**Date:** 07/16/2024

**Re:** **Damaged Roof Truss**  
Location: Lot 1 Pondhurst (98 Pondhurst Lane Fuquay-Varina, NC)  
JDS Project No.: RDU2407071  
Date of Inspection: 07/10/2024

S-3  
ATTIC FLOOR  
FRAMING PLAN

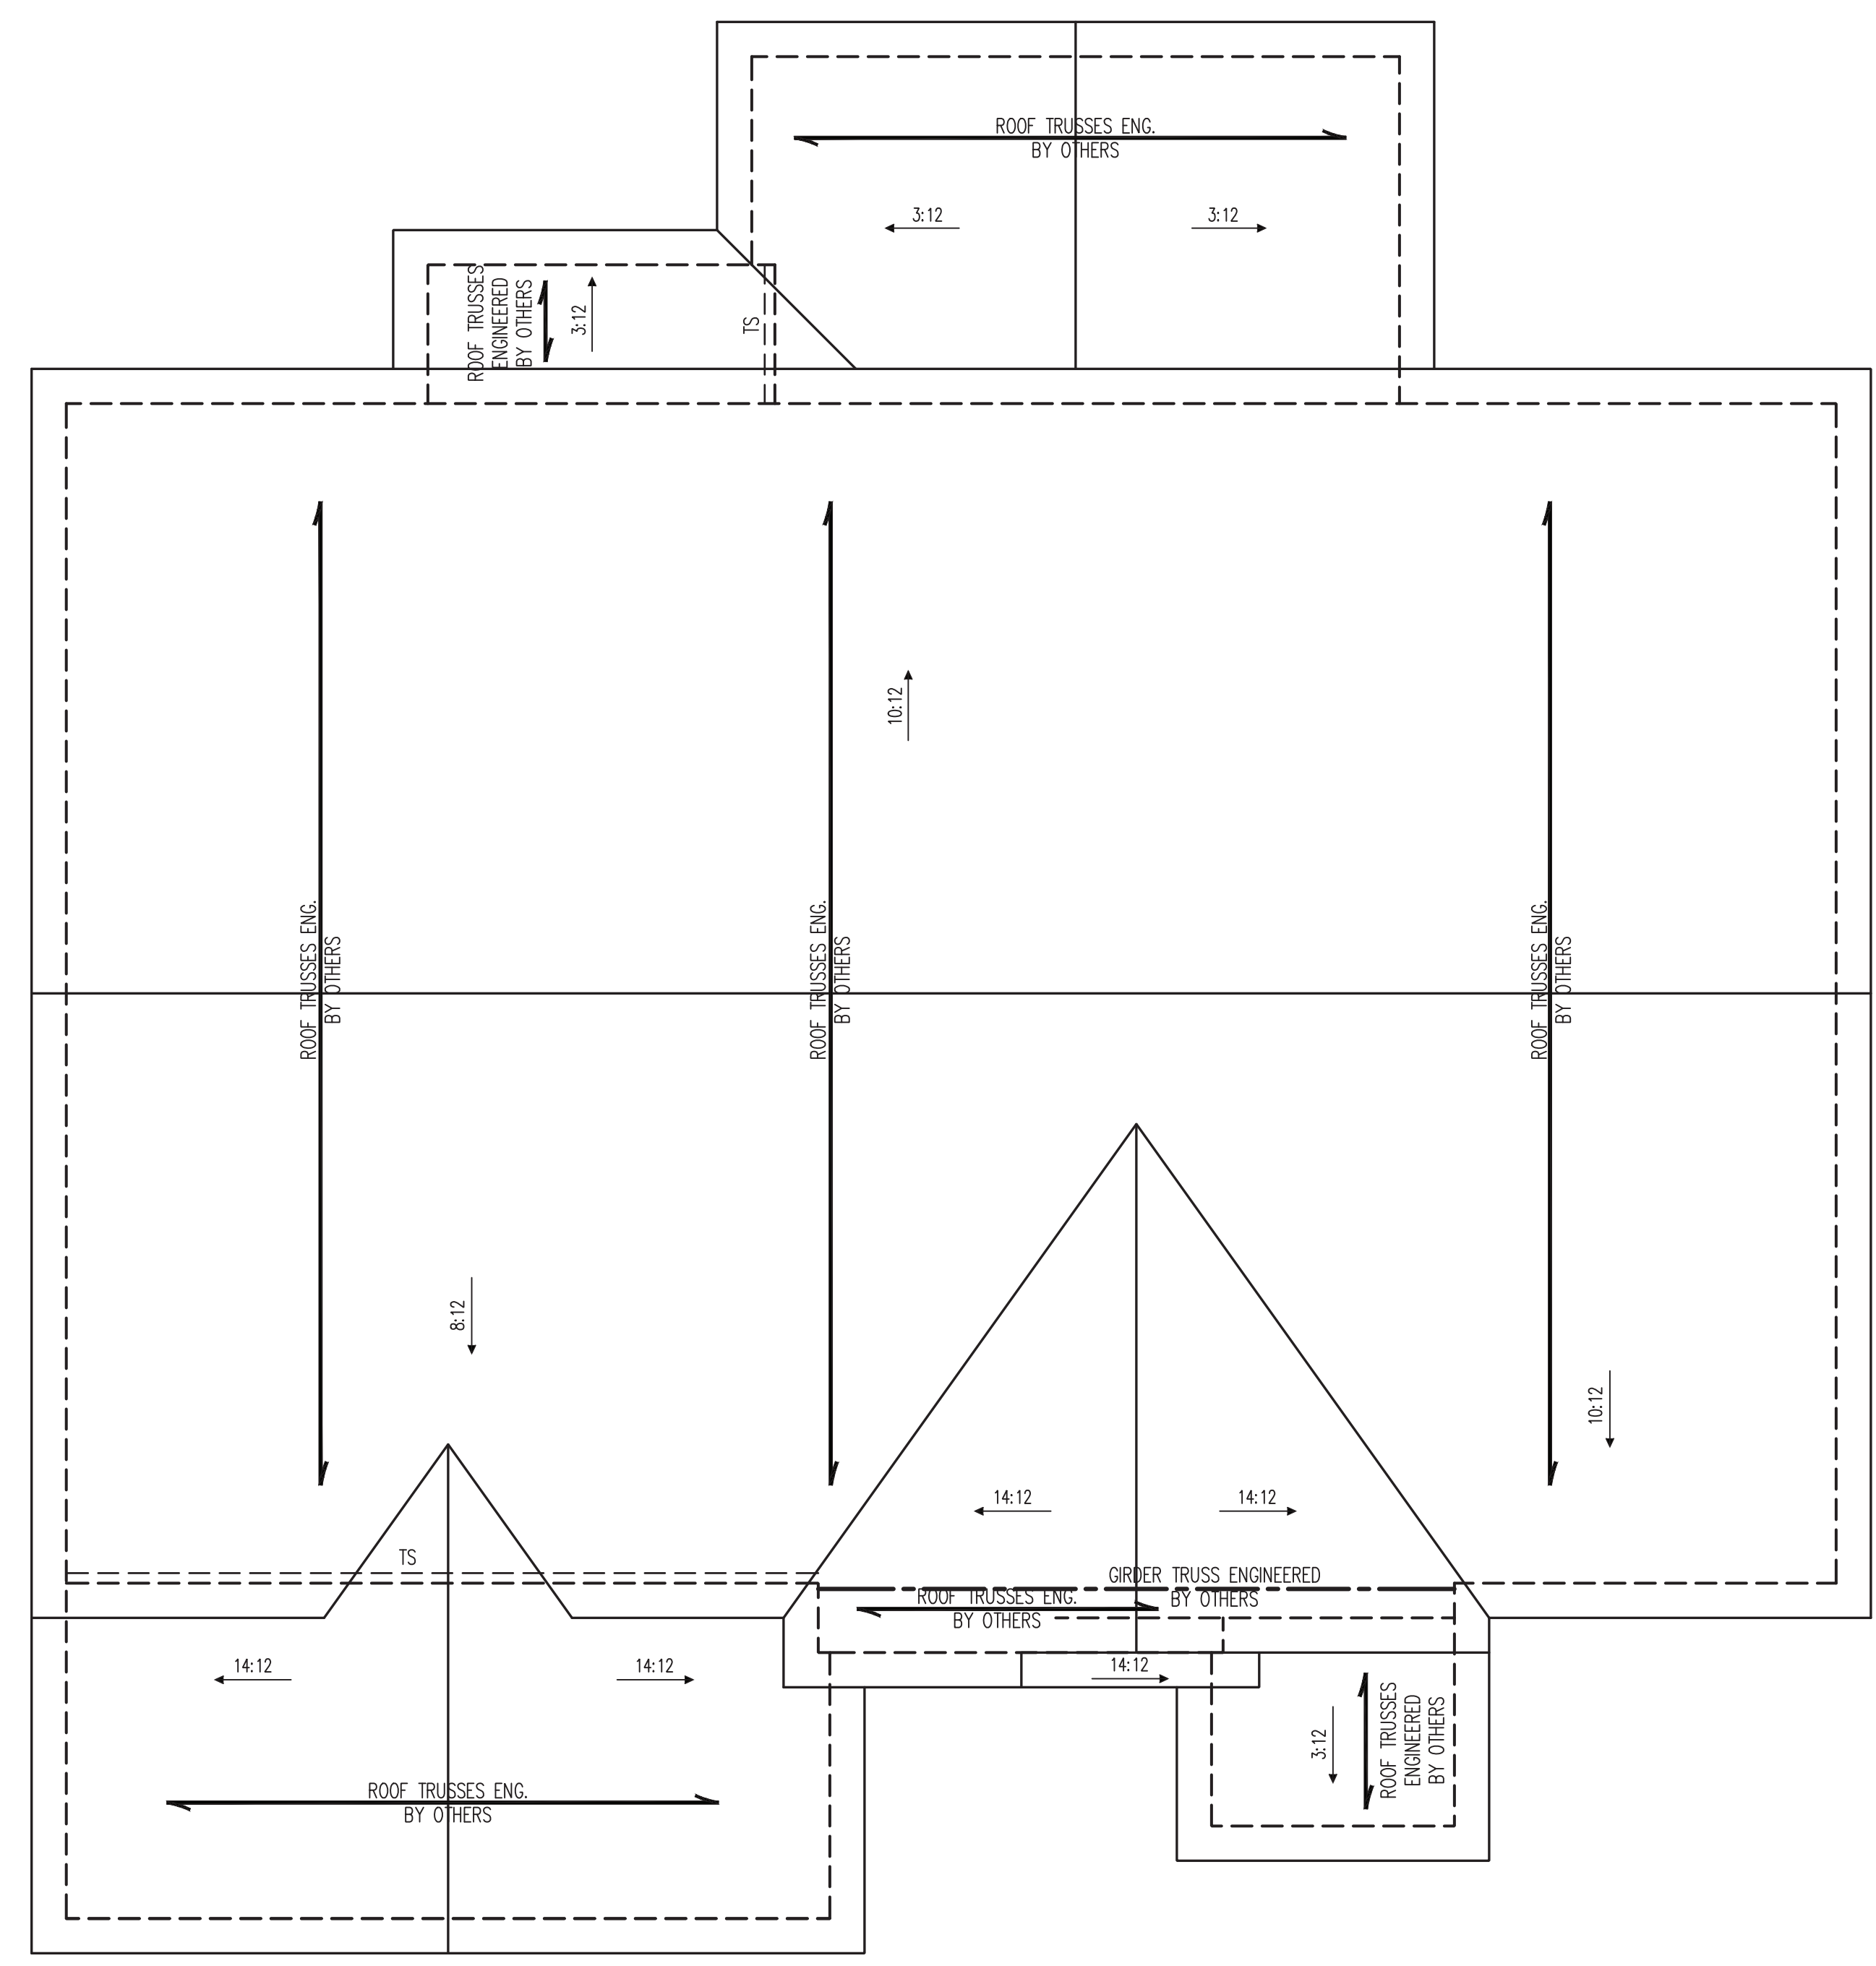
Modifications are needed to the B01 trusses at the front gable above the garage.

1. Floored storage area is needed to the left and right of the heated area.
2. The ceiling height is 8' and is needed to be 9' to match the 2<sup>nd</sup> floor.
3. A full size 2'6" door is needed at each side of the heated area to the storage.

1. Floored storage area:
  - a. Install a 10' 2x10 scab to each side, on (1) face, starting at the left and right ends of each truss at floor level, connected with (2) 10D nails into each overlapped member.

2. Ceiling height:
  - a. Carefully remove web 4-7 that makes up the current ceiling joist and install a new 2x4 web at the 9' ceiling level connected to the top chord on each end with a 16" x 16" x 7/16" OSB gusset on each side with (2) 6D nails at 3" o.c. into each overlapped member.

3. Door installation:
  - a. The vertical members of one of the B01 trusses will need to be removed to install framed door openings in order to access the attics on the left and right. At the truss that is to be modified, install a full length 1-3/4" x 14" LVL spanning from the 11 bearing location to the 23 bearing location. Ensure the LVL has full bearing on the top plates, and attach the LVL with (2) rows of 10d nails spaced 6" on center into all covered members.

- b. Remove the 3-21 and 8-13 members, do not damage the gusset plates.
  - c. Frame in a door opening as needed.
